ESTEBAN RODRIGUEZ RANCH

GRADING AND EROSION CONTROL PLANS

Comments provided on GEC Plans are preliminary in nature, given that Early Grading is not requested with this SP.

EDARP Filing No:
SP245 & SF#### (TBD)

ESTEBAN RODRIGUEZ RANCH
 GEC PLANS
 SHEET 3 OF 9
 JOB NO. 25277.00

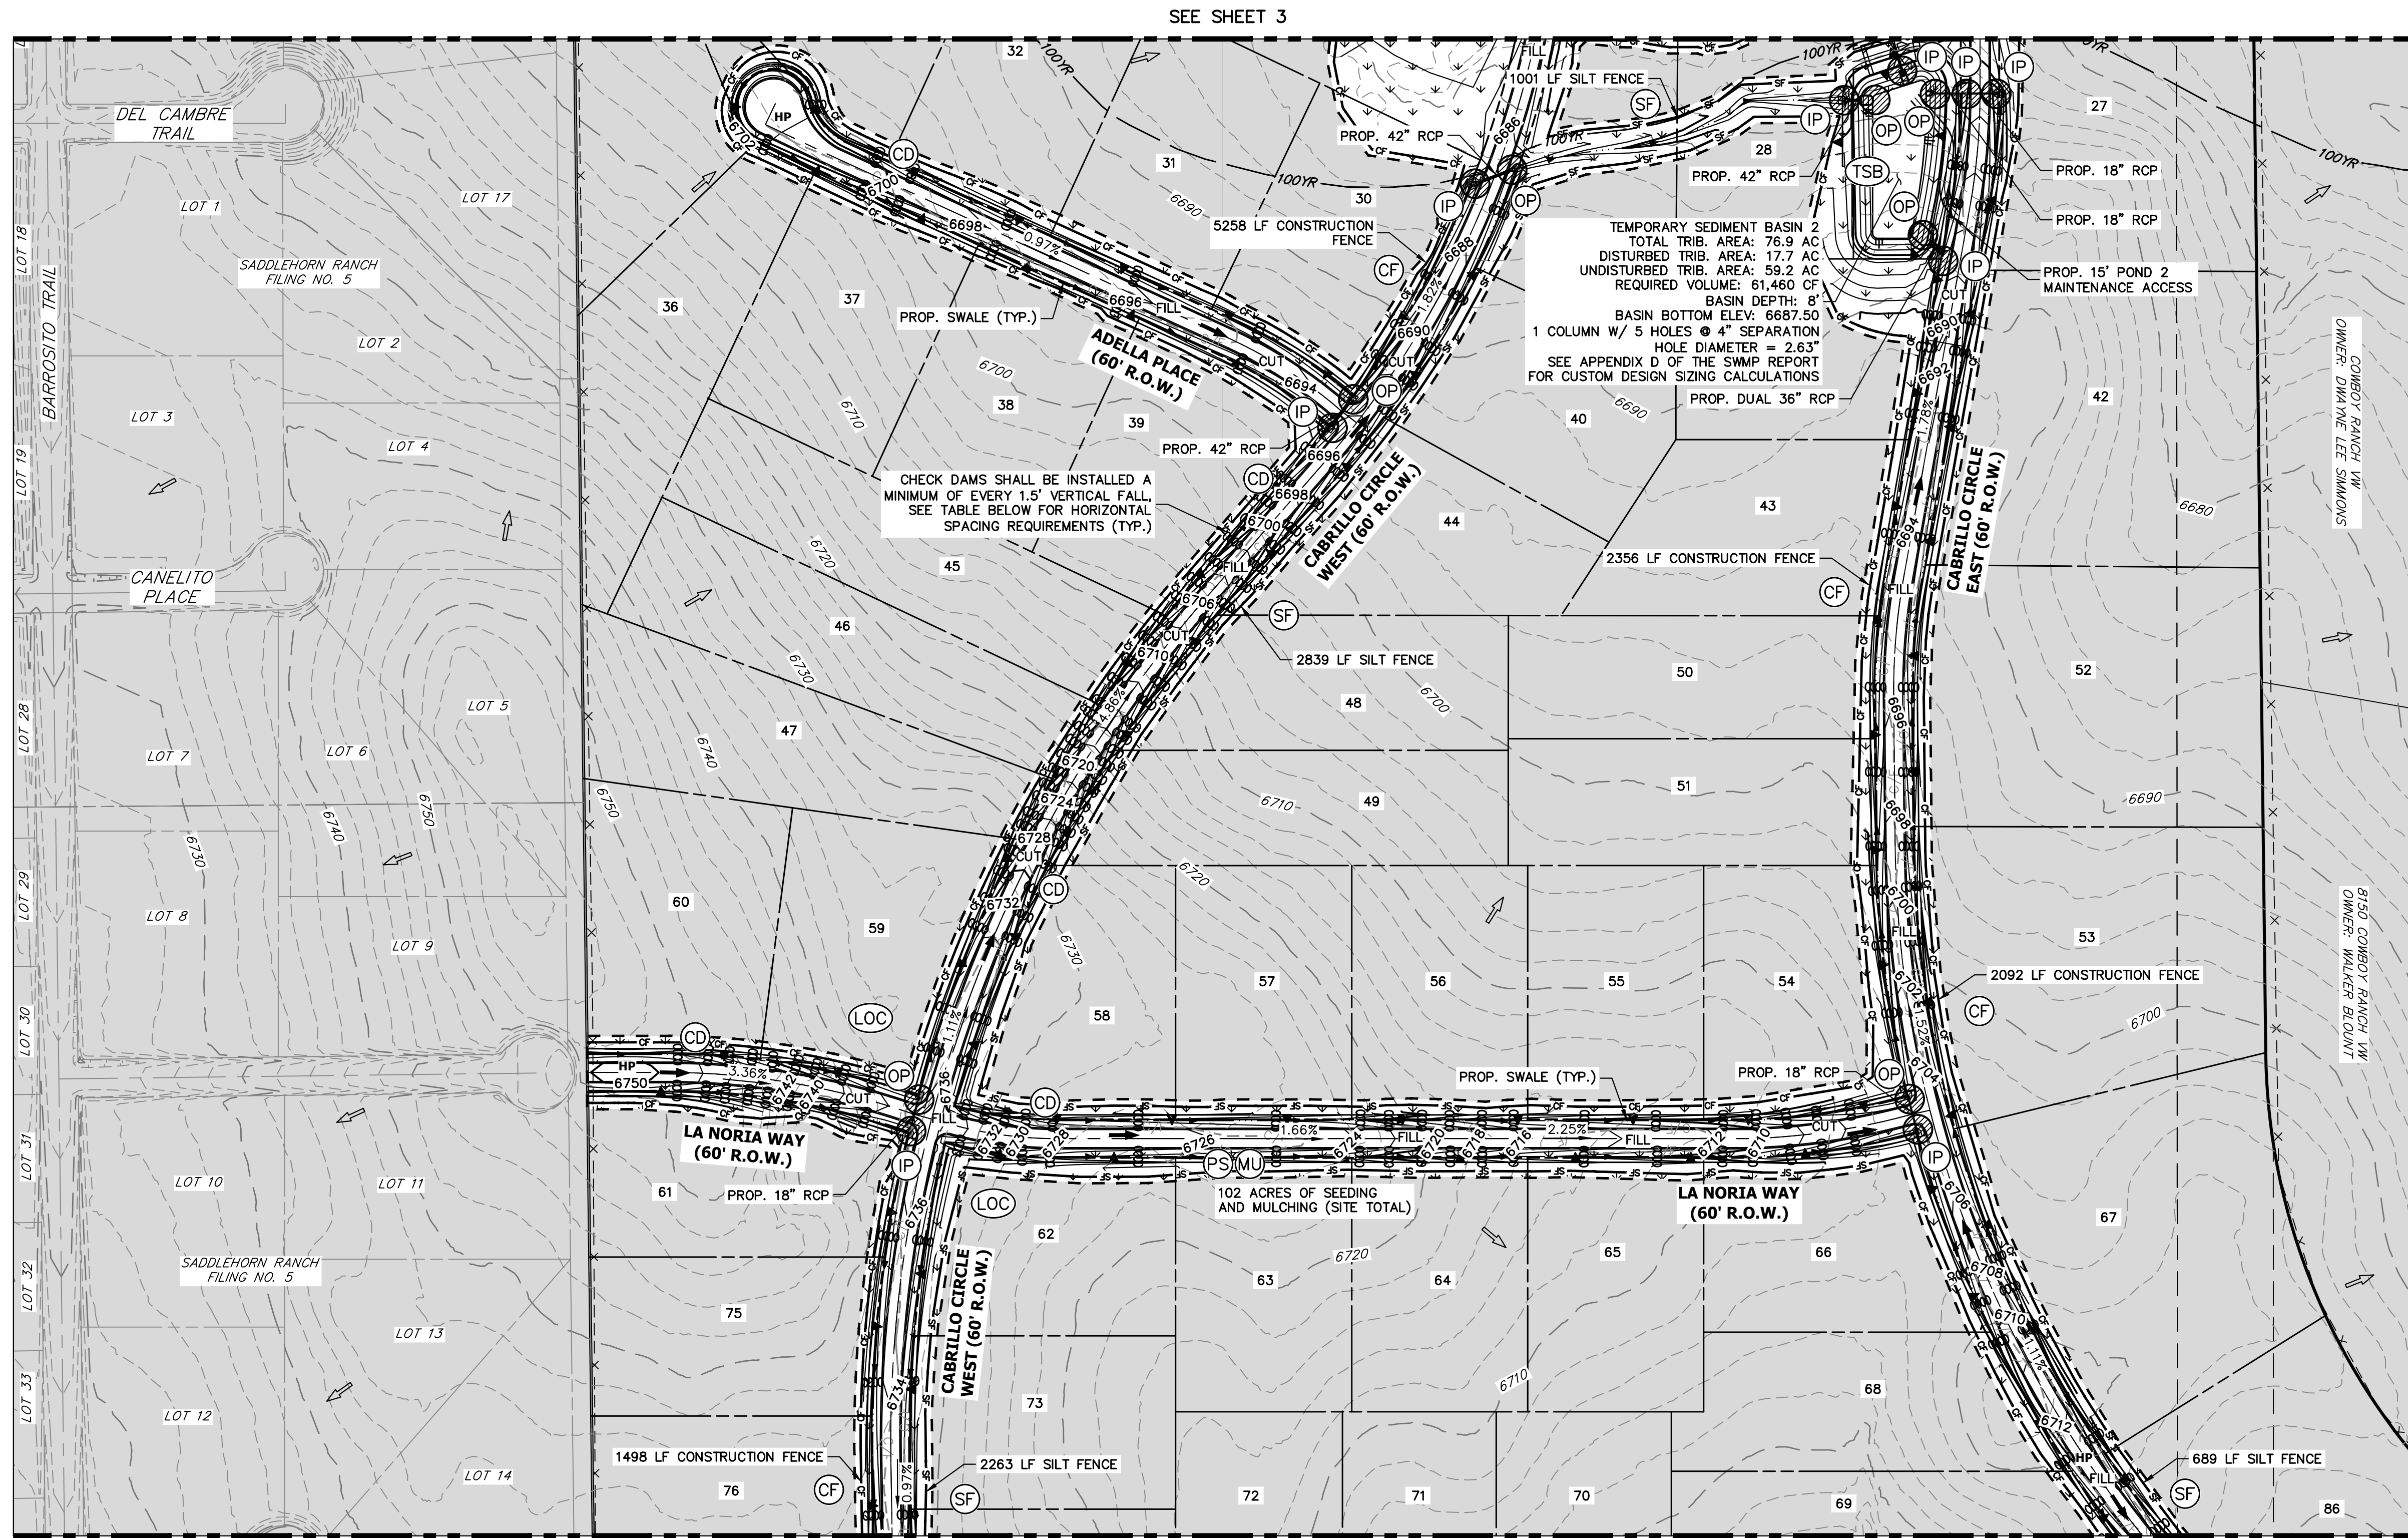
GEC Checklist Items H and M. If "limits of disturbance" and "construction boundary" are the same, change to "limits of construction/disturbance" or otherwise show as separate line types for each on the legend and figure.
